Current Zoning: INST(CD) (institutional, conditional) and N1-A (neighborhood 1-A)
Proposed Zoning: NC(CD) (neighborhood center, conditional)

Approximately 4.62 acres located at the northeast intersection of Harwood Lane and Mt. Holly-Huntersville Road, west of Country Lane.

The petition proposes to allow a 12,000 square foot childcare center or medical office and 20,000 square feet of nonresidential uses. A portion of the site is entitled for a childcare center and is currently developed with a single-family dwelling.

RZ-1.0

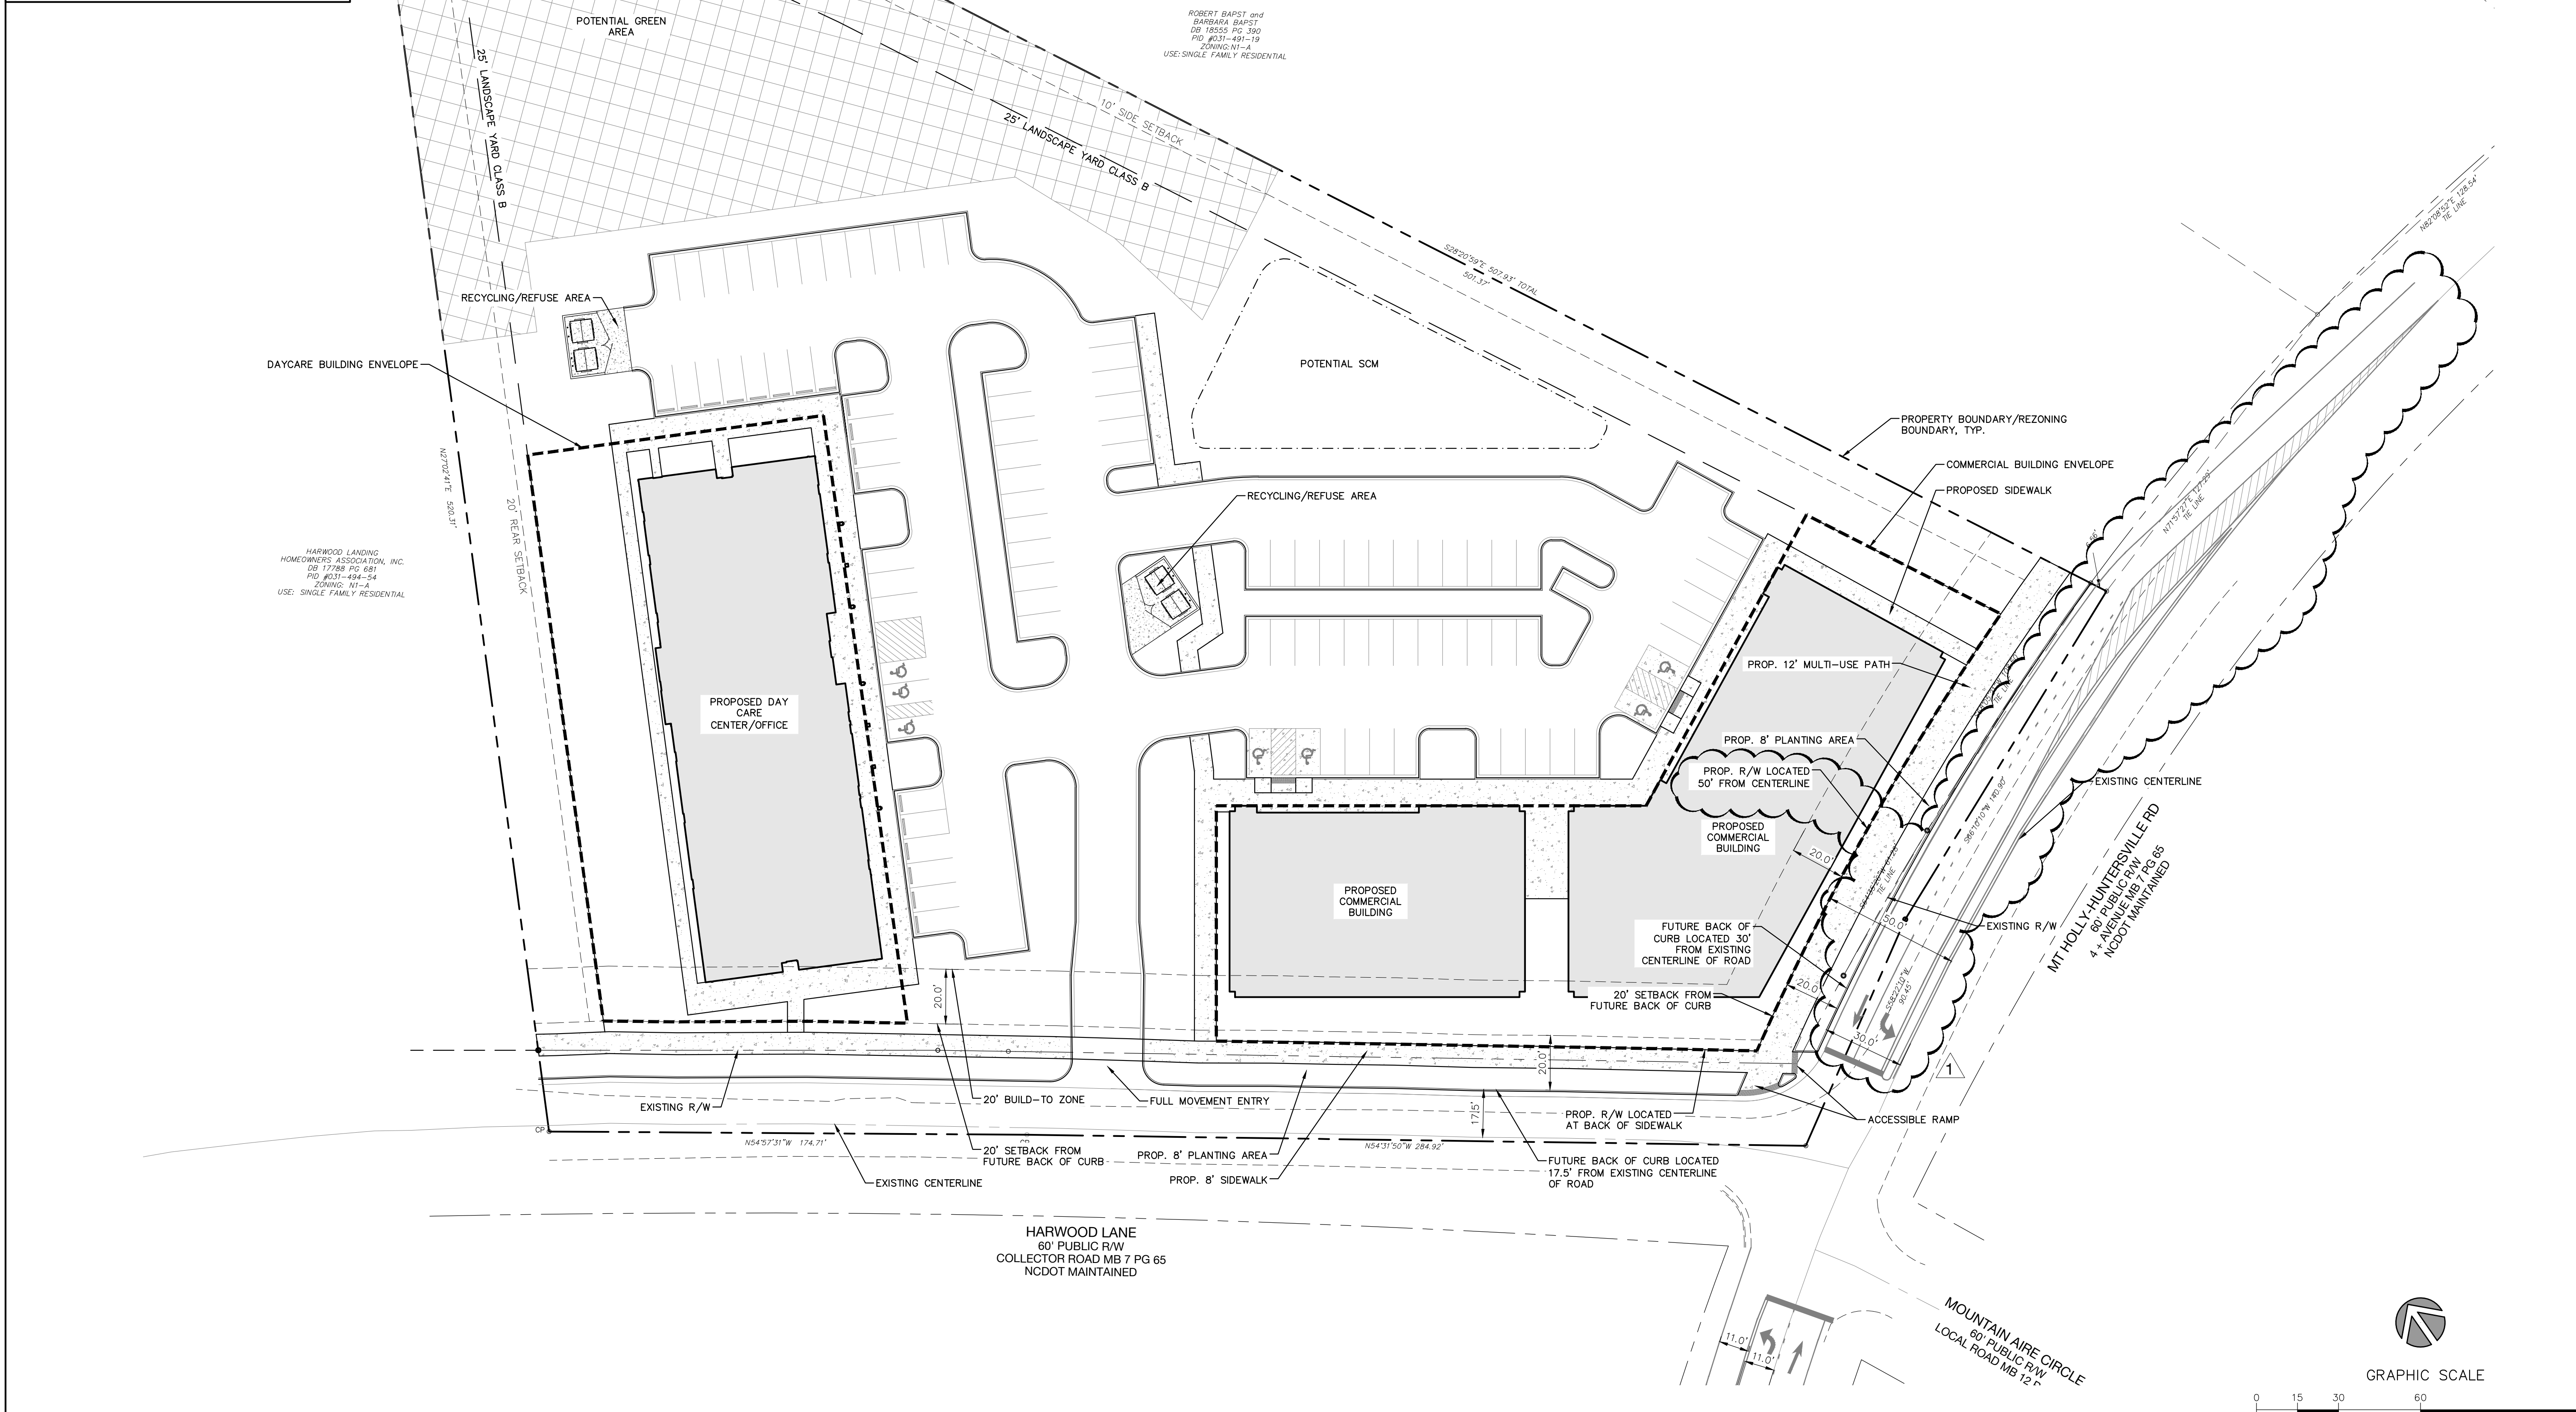
2. Urban Forestry: Green area shown does not meet standards. A large section of what is being shown a protected tree canopy does not have any trees.
3. Tree Survey for Conditional Zoning Map Amendment. A tree survey shall be required for all conditional zoning map amendments.

RZ-2.0

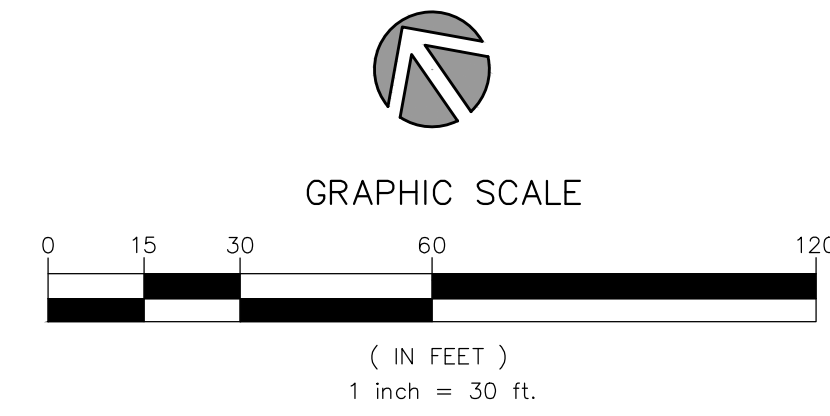
1. Revise CTR summary table. The solid waste internal to the site is not by location and just 14 points for having it internal for the whole site. Additionally, we can only give credit for the SUP along Mt. Holly Huntersville. Looks like there is approximately about 215 feet of SUP along Mt. Holly Huntersville. Frontage sidewalk that would be required by the ordinance otherwise does not count towards the multimodal mitigation points unless its physical improvements for bicycle or transit modes required by the UDO.

4. Conditional note numbering is incorrect. Permitted uses are described in Section 2 notes state that they are described in Section 3.
-
